**WELWYN HATFIELD BOROUGH COUNCIL  
EXECUTIVE DIRECTOR - PLANNING, PUBLIC PROTECTION AND GOVERNANCE**

**DELEGATED APPLICATION**

**Application No:** 6/2016/1067/FULL  
**Location:** Oshwal Centre, Coopers Lane Road, Northaw, Potters Bar, EN6  
 4DG  
**Proposal:** Erection of storage building following demolition of existing structures  
**Officer:** Mr S Dicocco

**Recommendation:** Refused

EXISTING AND PROPOSED FRONTS
AND SECTIONS

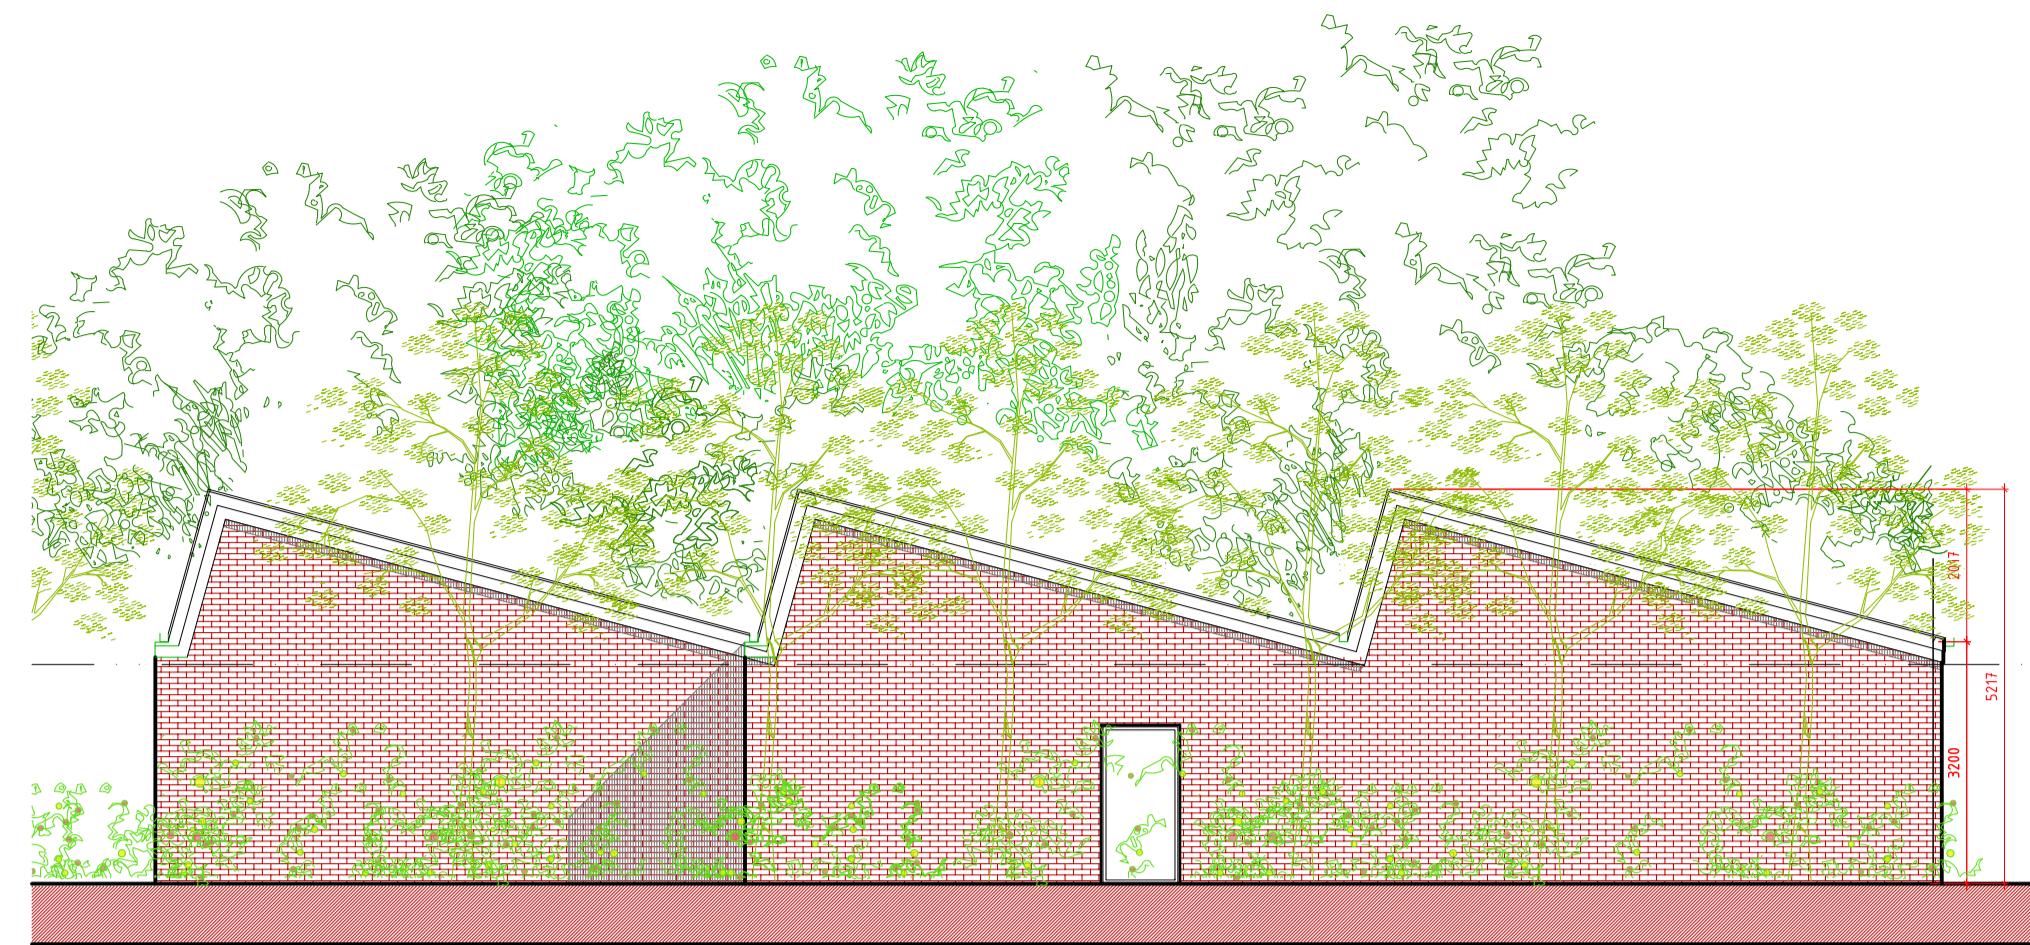
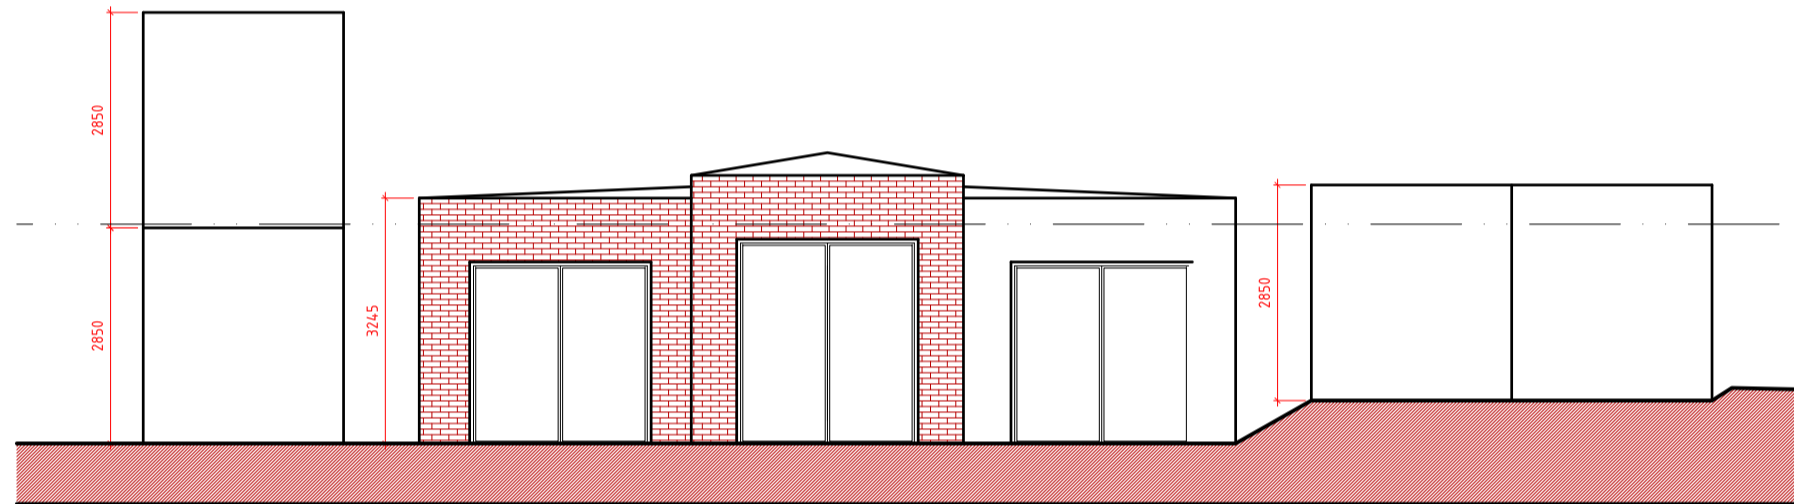
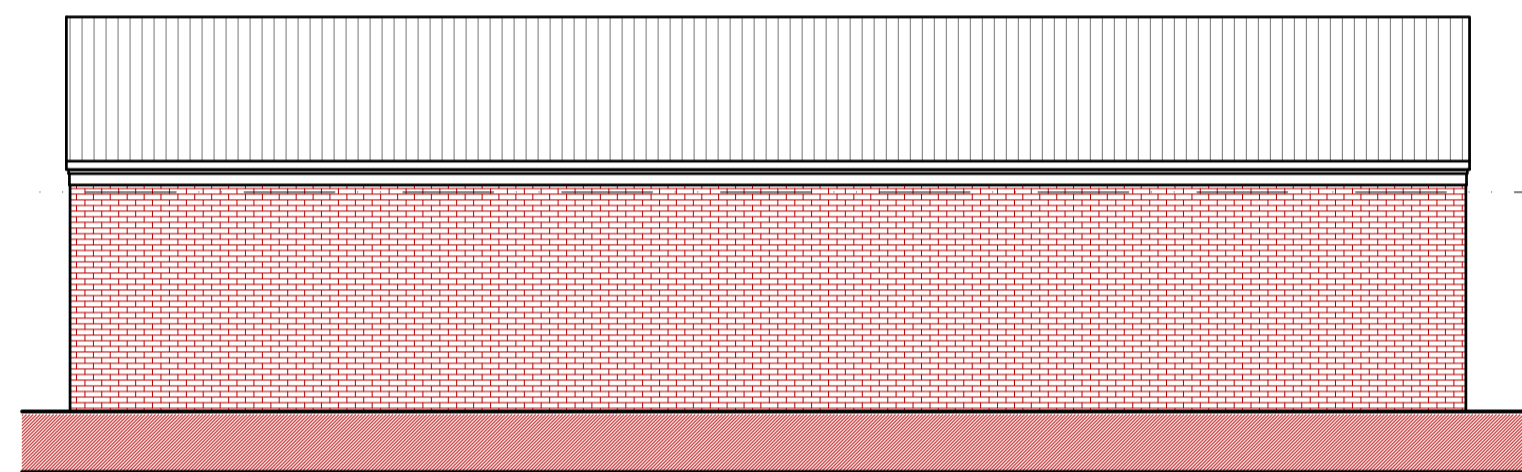
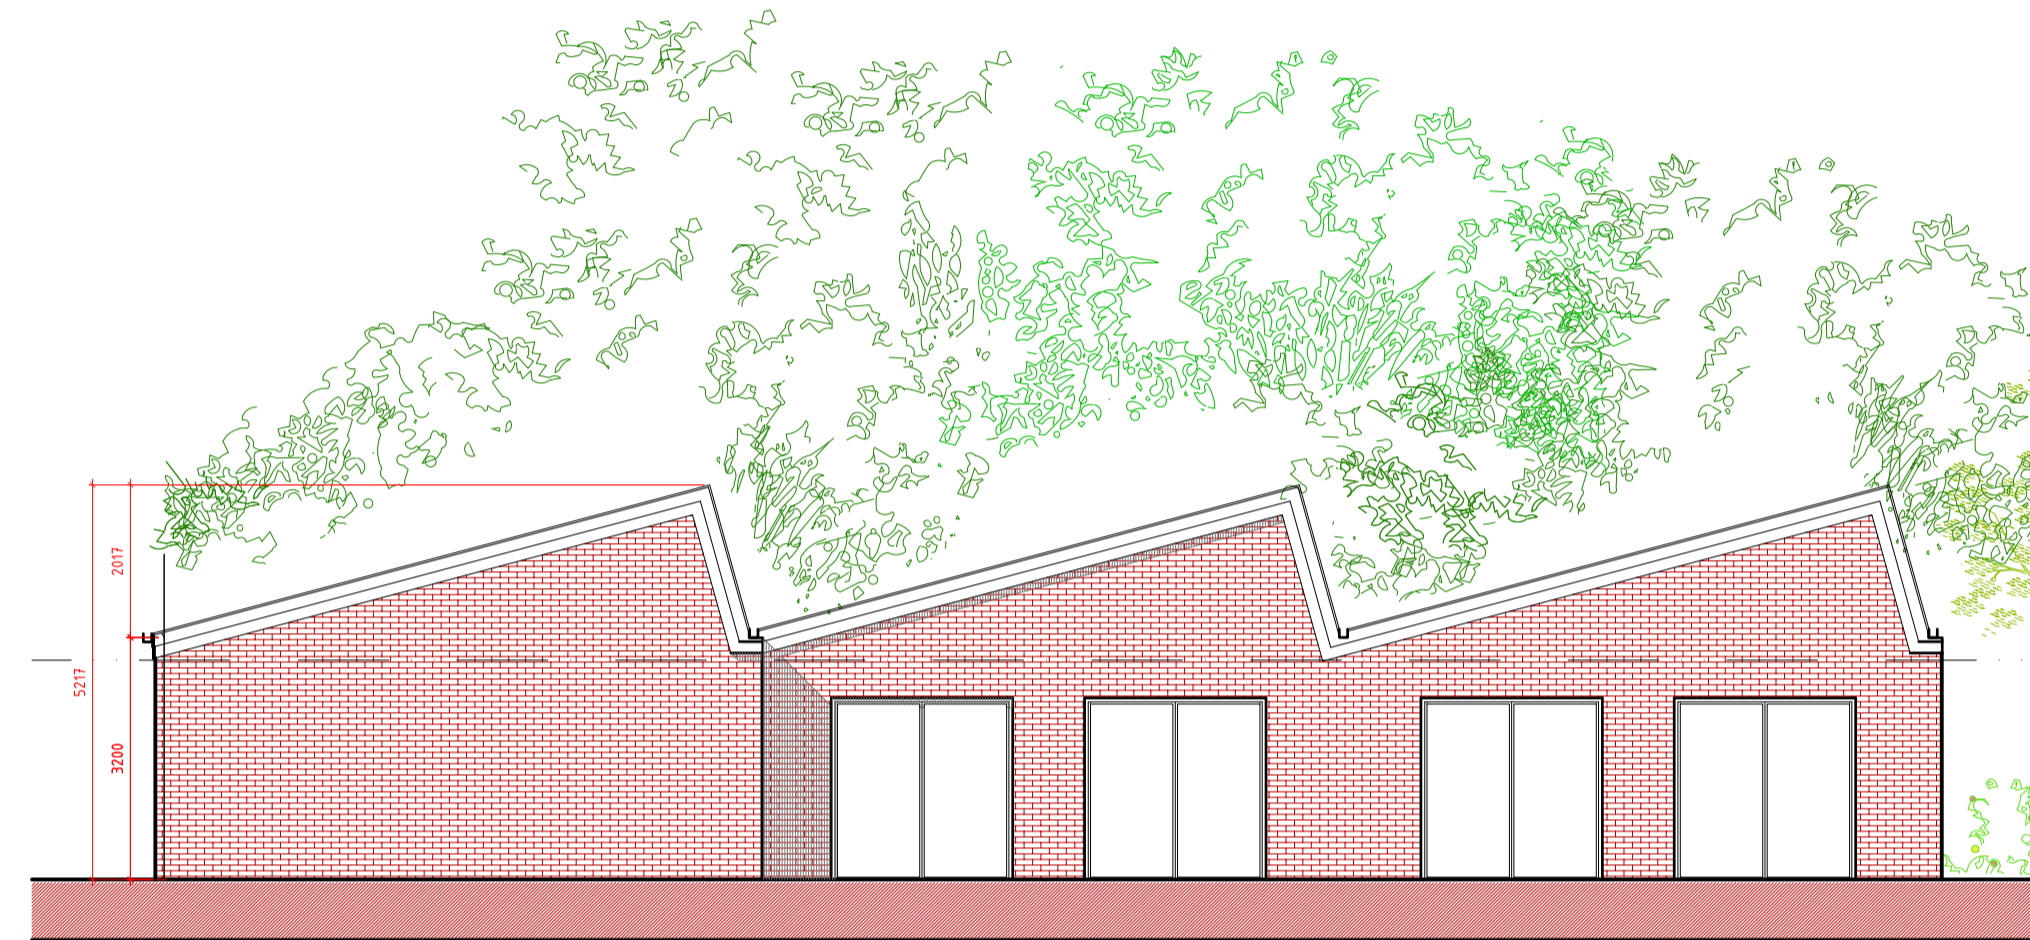
floor space. Alongside this, the proposed building would be higher than majority of the existing structures upon the site. The proposed building's apex would measure 0.9m higher than the existing storage building and approximately 0.95m lower than the double storey ventilation structures. In terms of volume, the existing site contains approximately 934 cubic metres of form, and the proposed building would contain approximately 1339 cubic metres. This represents an approximate 43% increase in volume as a result of the development
